PUBLIC WORKS DEPARTMENT
SIDEWALK & DRIVEPAD INSPECTION

PROJECT TITLE: Burger King - Wyoming ZONE ATLAS/DRNG. FILE #: F-19/D36
DRB#: 98-213 EPC #: WORK ORDER #:
LEGAL DESCRIPTION: Tract "B", Block 1, American Heritage North Unit 3
CITY ADDRESS: 5315 Wyoming Blvd. NE
ENGINEERING FIRM: Chavez-Grieves CONTACT: Joseph DeFronzo
ADDRESS: 5639 Jefferson NE PHONE: 344-4080
OWNER: M&M Bros. Inc. CONTACT: Tom McCollum
ADDRESS: 11000 Bermuda Dunes NE Alb. 87111 PHONE: 292-5744
ARCHITECT: Nims-Calvani CONTACT: Myron Saldyt
ADDRESS: 525 San Pedro NE Ste. 110 PHONE: 255-6400
SURVEYOR: Harris Surveying CONTACT: Anthony Harris
ADDRESS: 2412 Monroe St. NE PHONE: 889-8056
CONTRACTOR: Gerald Martin CONTACT: Bob Cardenes
ADDRESS: 8501 Jefferson NE PHONE: 828-1144

RE: REVISED DRAINAGE PLAN FOR BURGER KING @ WYOMING & SPAIN
(F19-D36) REVISION DATED 8/5/98

RE: REVISED DRAINAGE PLAN FOR BURGER KING @ WYOMING & SPAIN
(F19-D36) REVISION DATED 6/1/98

## CONCEPTUAL GRADING PLAN

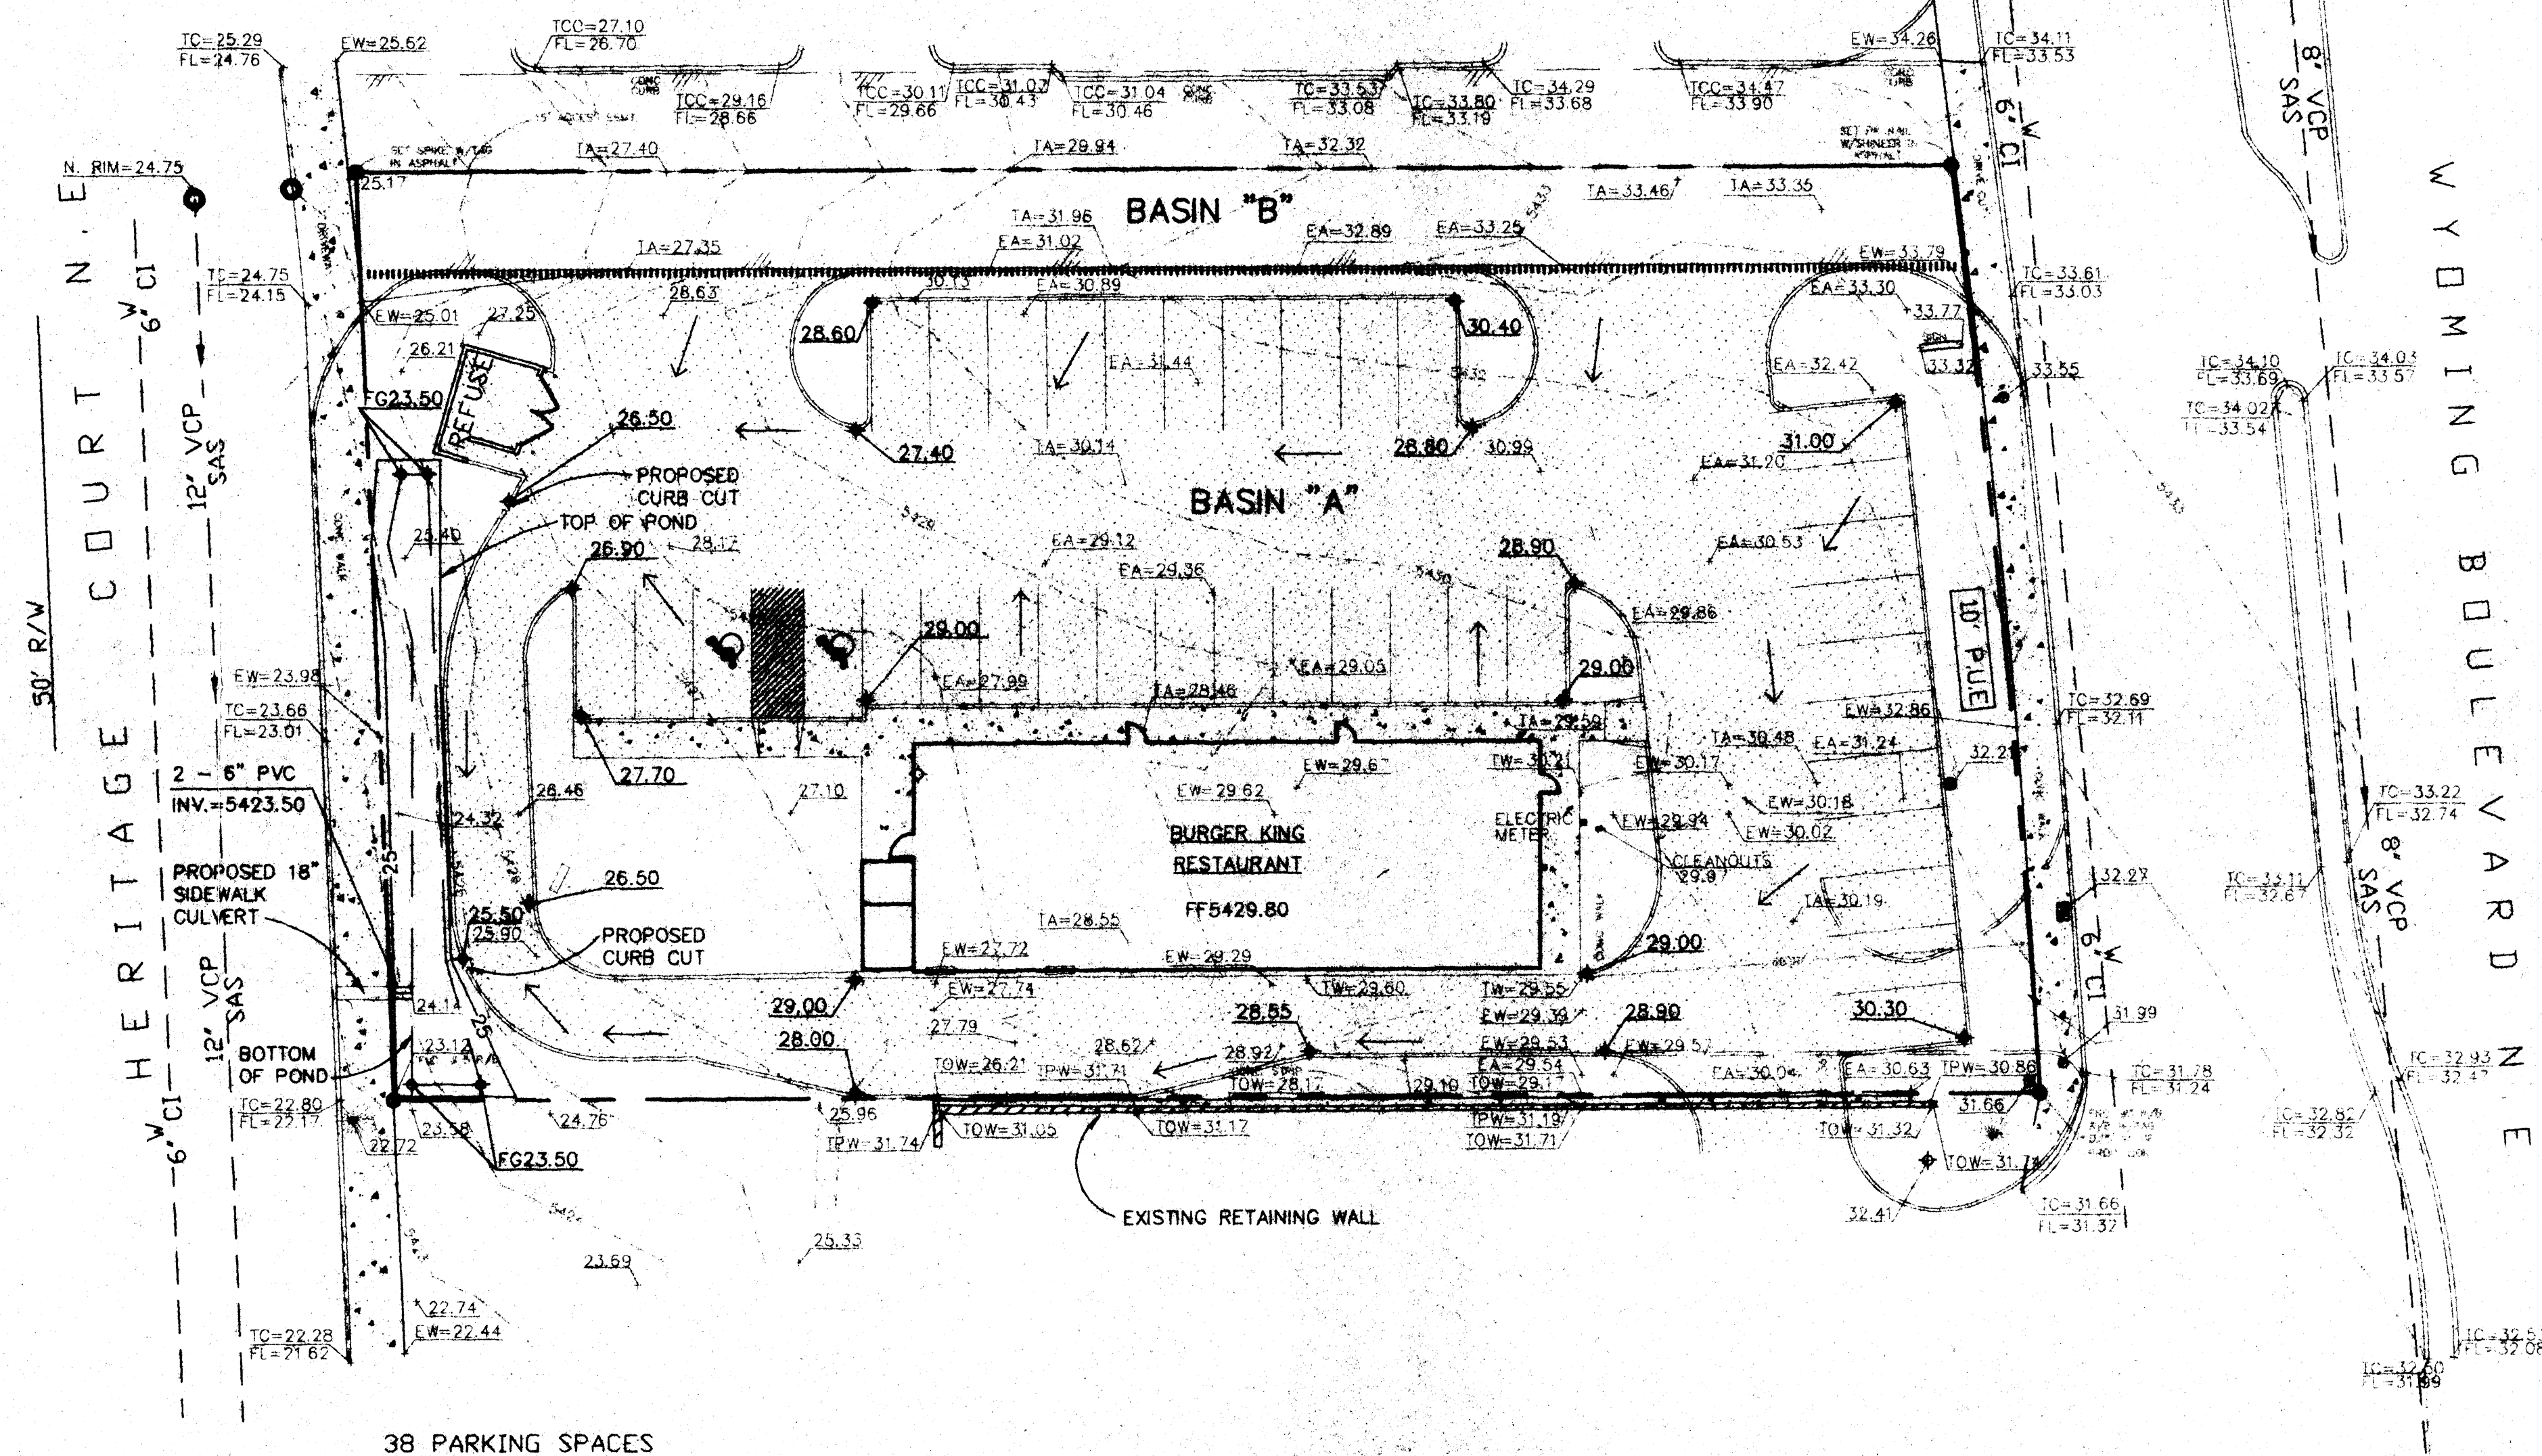
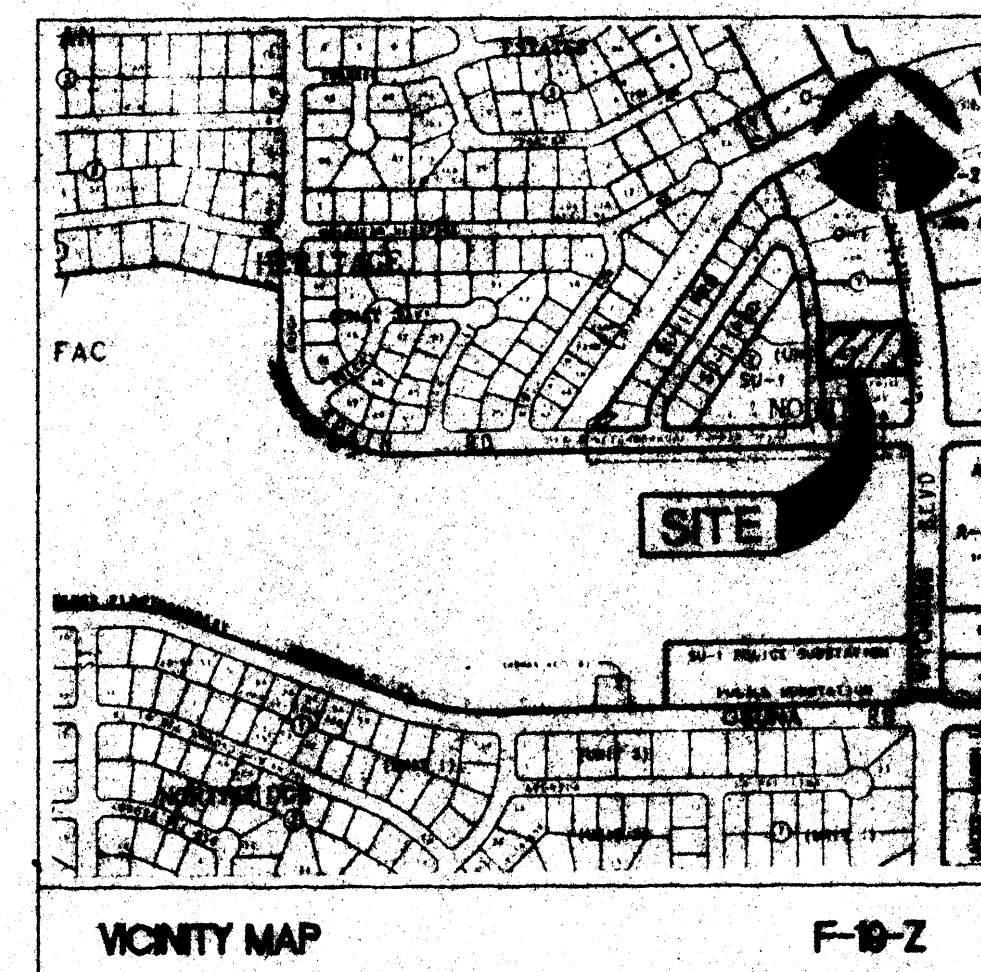
1. Six notes and signature block from the SO19 format within the plan drawing. *no*
2. Close proximity of the proposed pond to the street pavement, please address.
3. Location and direction of the roof drains.
4. Identify the 100-year water surface elevation for the pond on the plan drawing.
